Project Name / File No.: Soper Hill Station (Permit #: PA22-030)
Applicant: Soper Hill Station, LLC
Project Description: Administrative Review – Site Plan
Site Address: 8907 Soper Hill Rd, Marysville
Review: Applicant's Response to (1st) Review

This letter serves as the Applicant's formal response to the 1st review comments received from the City of Marysville on August 19, 2022 to our recent application materials submitted to the city on July 5, 2022. To ensure that each of the comments have been responded to, we have incorporated each of the City's comments along with the Applicant's response to each below. The responses below are to inform you that we have addressed each of the City's comments so the review of the application may continue.

JOB NUMBER: C22-141
DRAWING NAME: C22141SP-CS-PL
DESIGNER: JMH
DRAFTING BY: DPN
DATE: 6-27-22
SCALE: 1"=50'
JURISDICTION: CITY OF MARYSVILLE

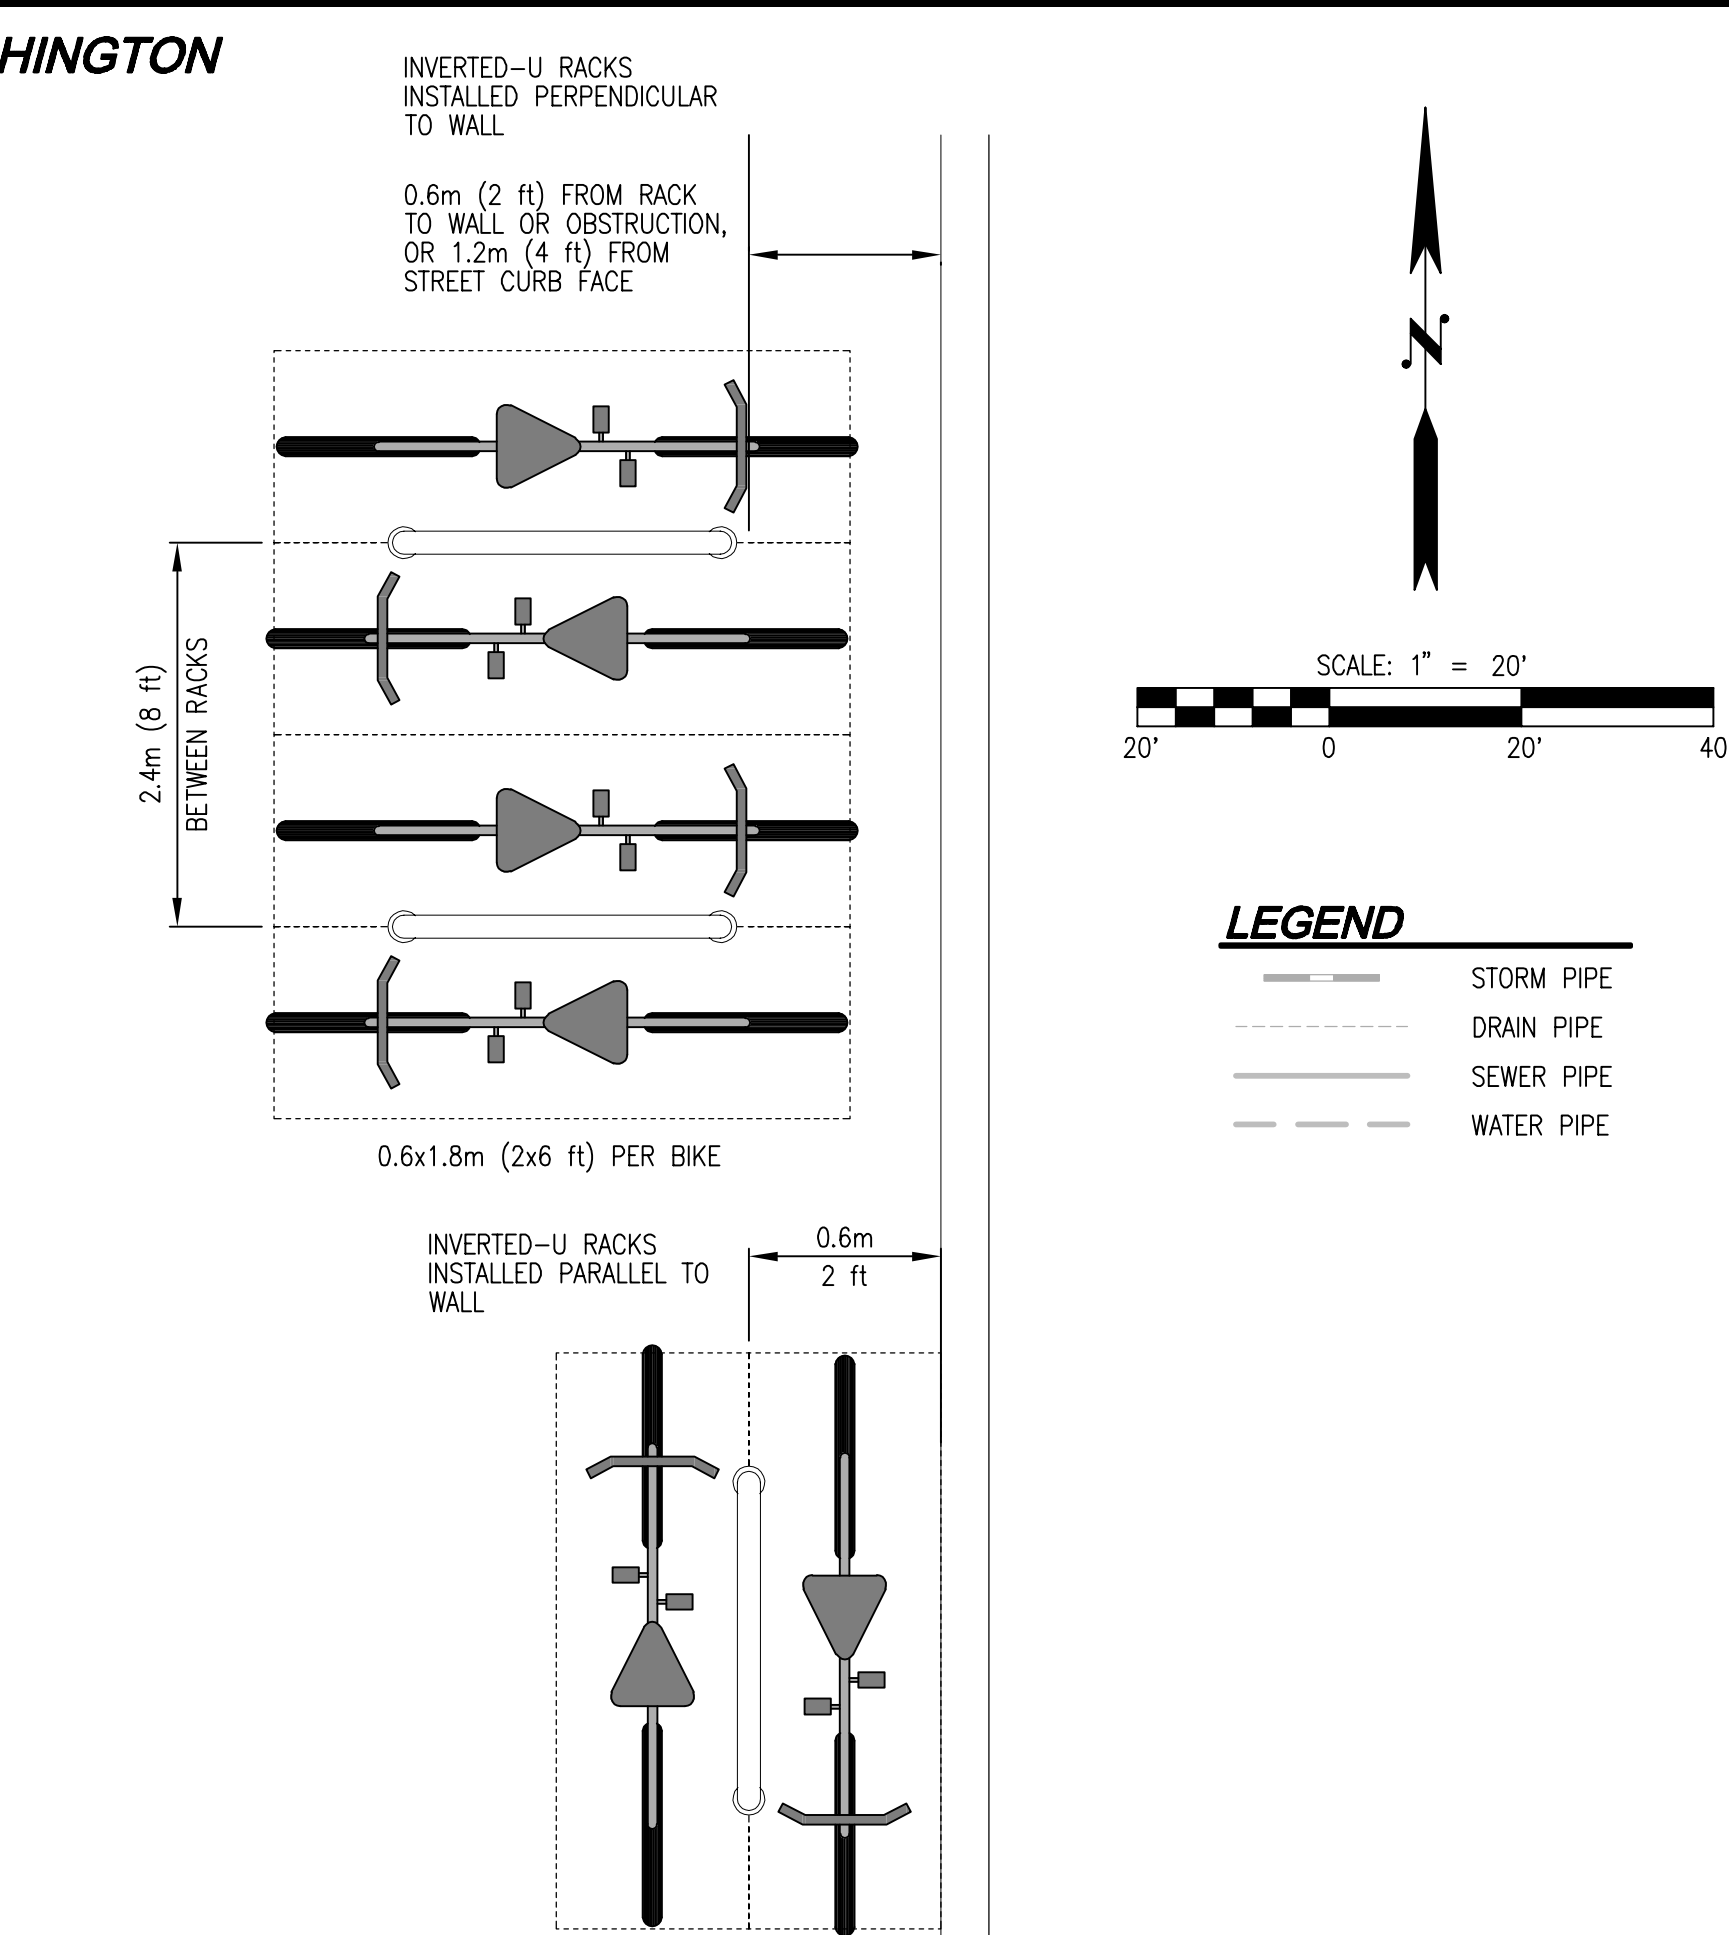
4. Amend Sheet SP-02, as follows:

a. Provide impervious surface calculations;

e. Amend the parking calculations to include building SF and math for calculating the required number of spaces, similar to the project narrative;

f. It appears that some of the proposed parking stalls measure 8' in width. 8.5' minimum required;

g. B.4.1.a. requires a side and rear setback of 15'. It appears the building is only setback 10' along the south property line

h. F.1.1 requires a 30' landscaping setback from Soper Hill Road and a 20' setback is required from Road A when a parking areas and drive aisles are located adjacent to these roadways. The Director may approve and condition reduced planter widths provided the design meets the intent of the standards and guidelines. For example, reduced widths may be allowed provided the landscaped area is supplemented with architectural features that help to define the street edge and maintain visual continuity along the street. Examples could include a decorative low wall made of stone or masonry that is used in conjunction with landscaping, and/or use of a landscaped trellis or architectural columns. For each method, it is important to maintain visibility at eye level (between 3 and 8 feet above the ground) between the street into the parking lot for safety.

i. F.2.4.a. requires service elements (i.e. solid waste disposal areas) to be located to minimize the negative visual, noise, odor, and physical impacts of the street environment, adjacent (on and off-site) residents or other uses, and pedestrian areas. The proposed location of the solid waste collection area will need to be relocated so that it is not visible upon entry into the site.

j. A minimum 5' L4 landscape buffer is required at the end of the row of parking on the northeast portion of the parking area.

Applicant's Response: Impervious surface areas have been included on the sheet indicated.

Applicant's Response: Parking calculations have been amended, calculations match between civil and architectural plans.

Applicant's Response: All stalls are drafted correctly with 8.5-foot minimum width, measurements indicated on redlined plans may be a result of an inaccurately scaled or poorly scanned PDF drawing.

Applicant's Response: Building has been adjusted to provide appropriate setbacks from property lines and overhead wire.

Applicant's Response: Per our previous conversation a Type L3 10-foot buffer has been provided along both Drive Aisle A and Soper Hill Rd. In addition, landscaping will be provided in the 5-foot planter strips between Soper Hill Rd and Drive Aisle A.

Applicant's Response: Garbage area has been relocated and screened.

Applicant's Response: This has been provided.

TITANIUM OFFICE, LLC
WHITE BARN - LOT 2
TURNING MOVEMENT PLAN

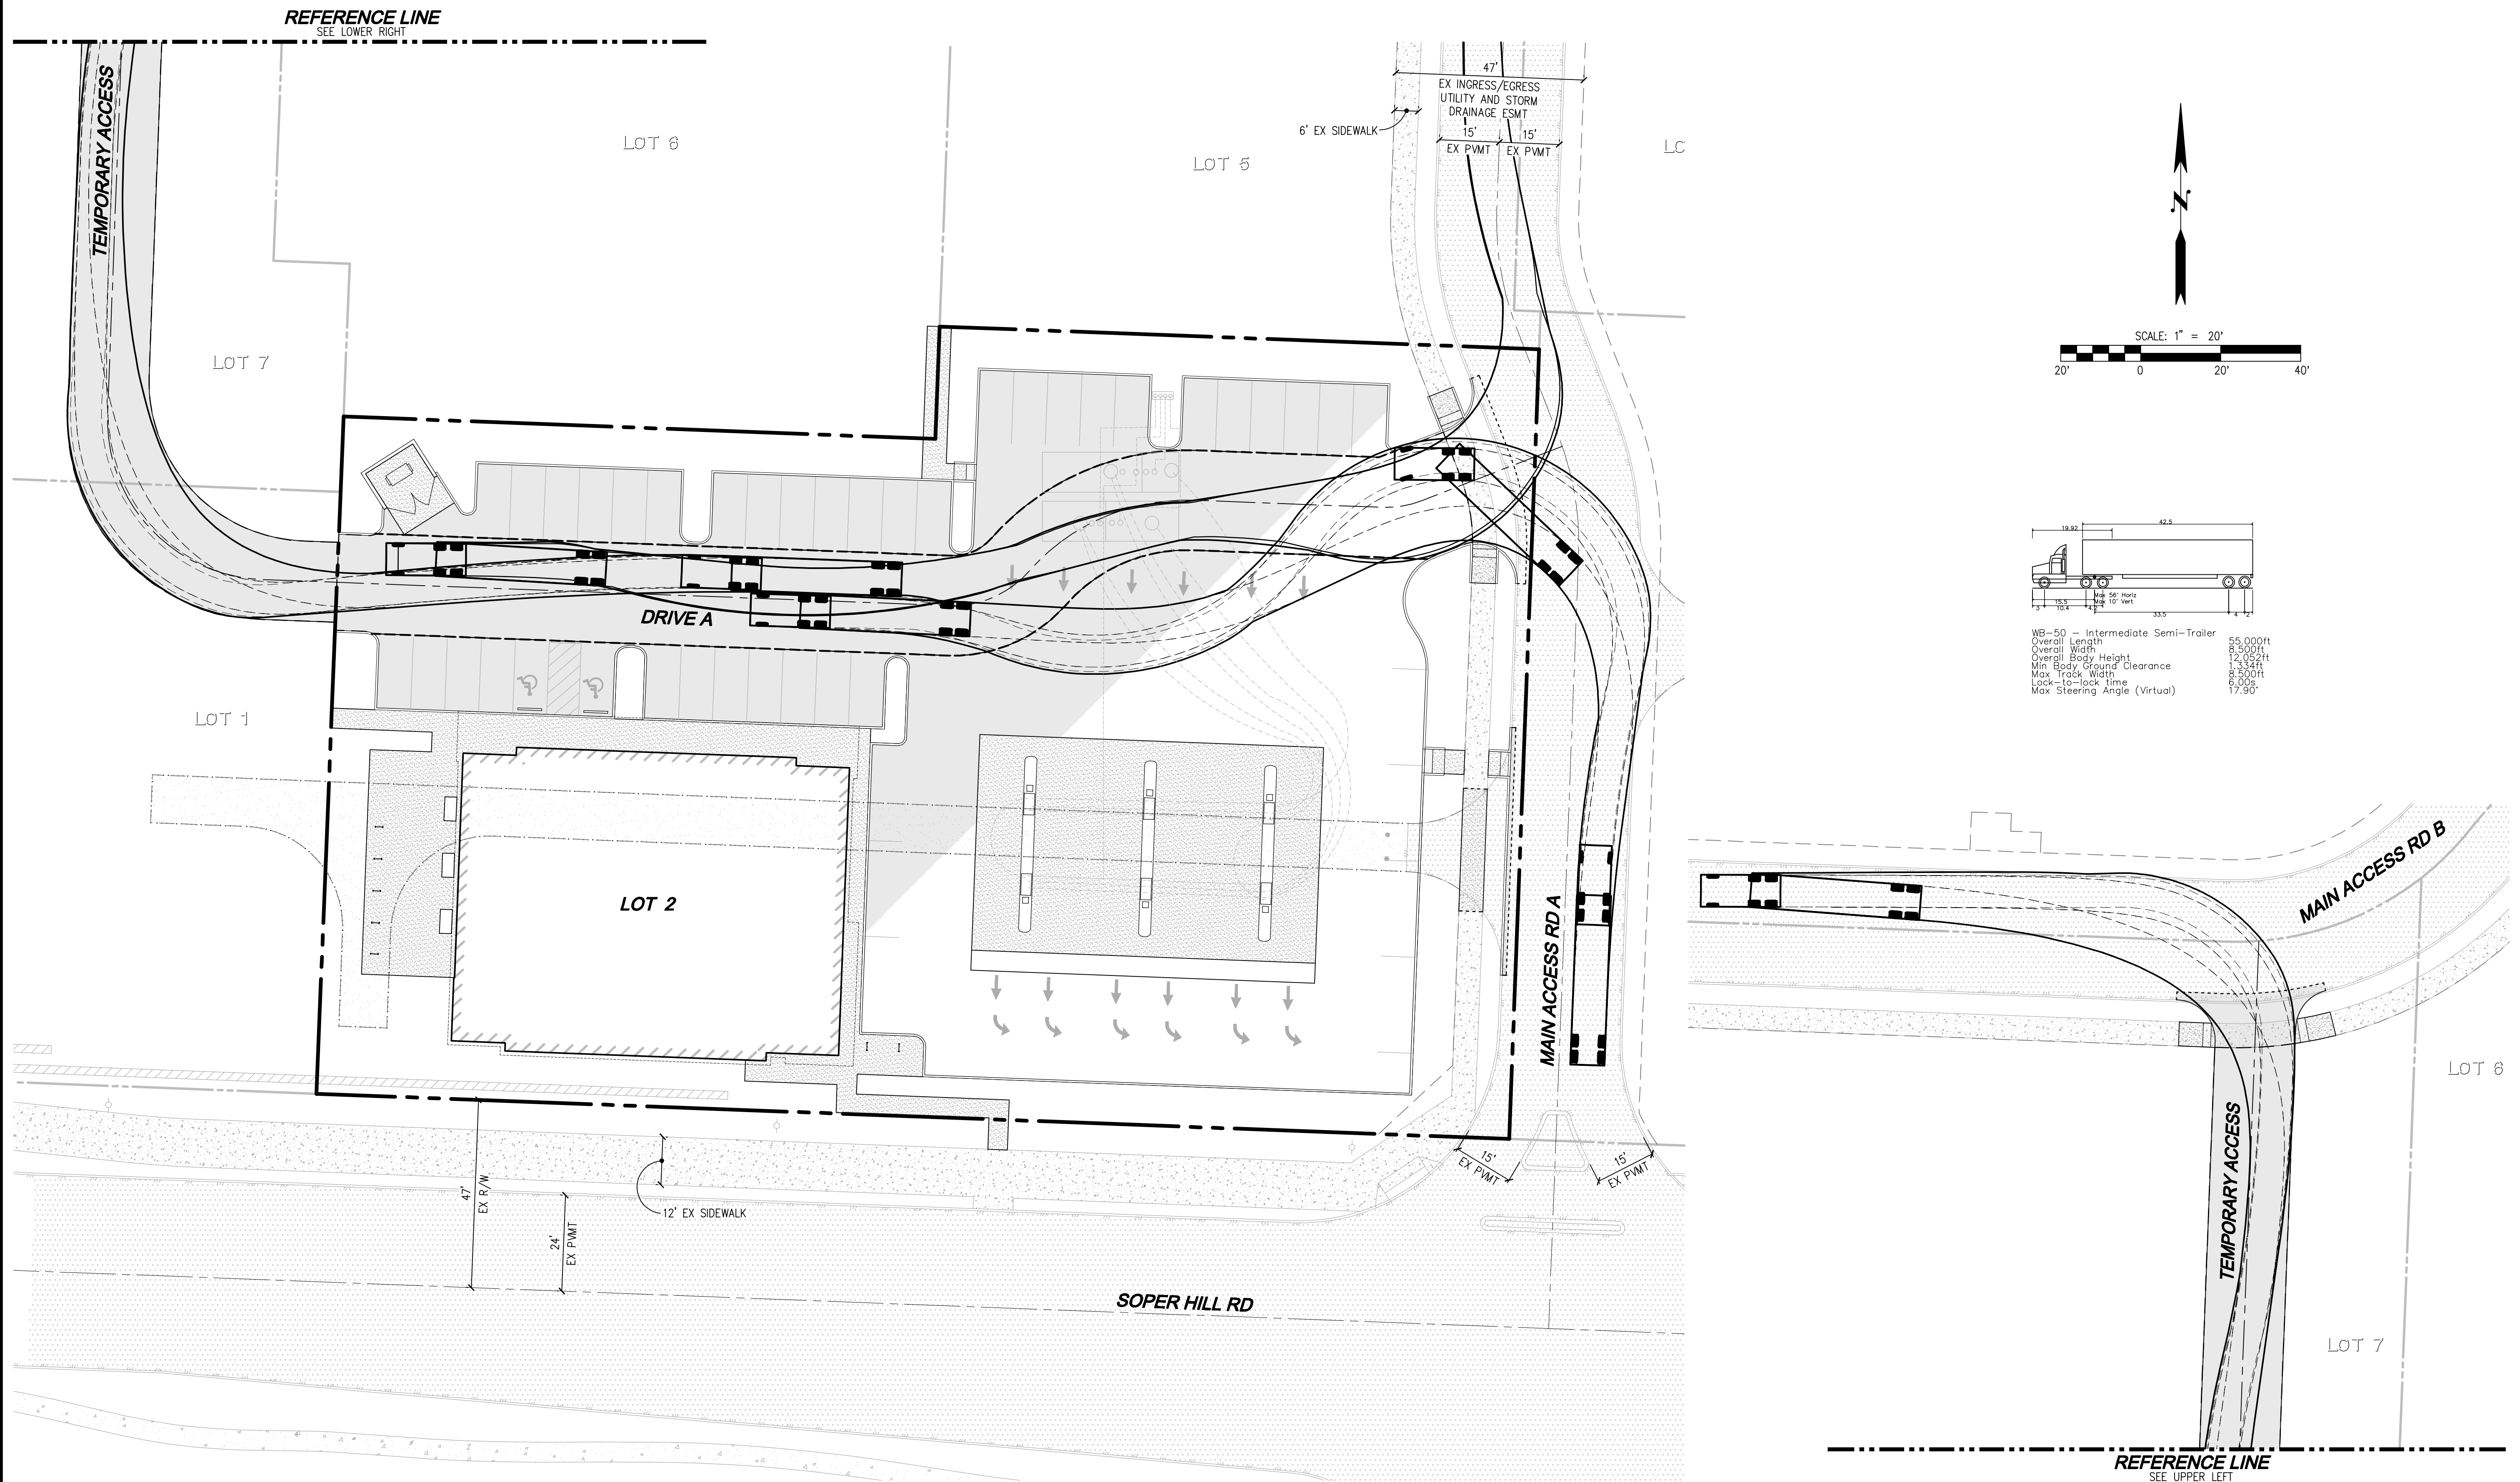
b. Provide an auto-turn exhibit with the formal land use application to ensure adequate circulation for both patrons and fueling trucks. Additionally, the applicant shall be required to demonstrate how a fueling truck can safely navigate through the White Barn Center;

Applicant's Response: Auto-turn plan have been added to the plan set.
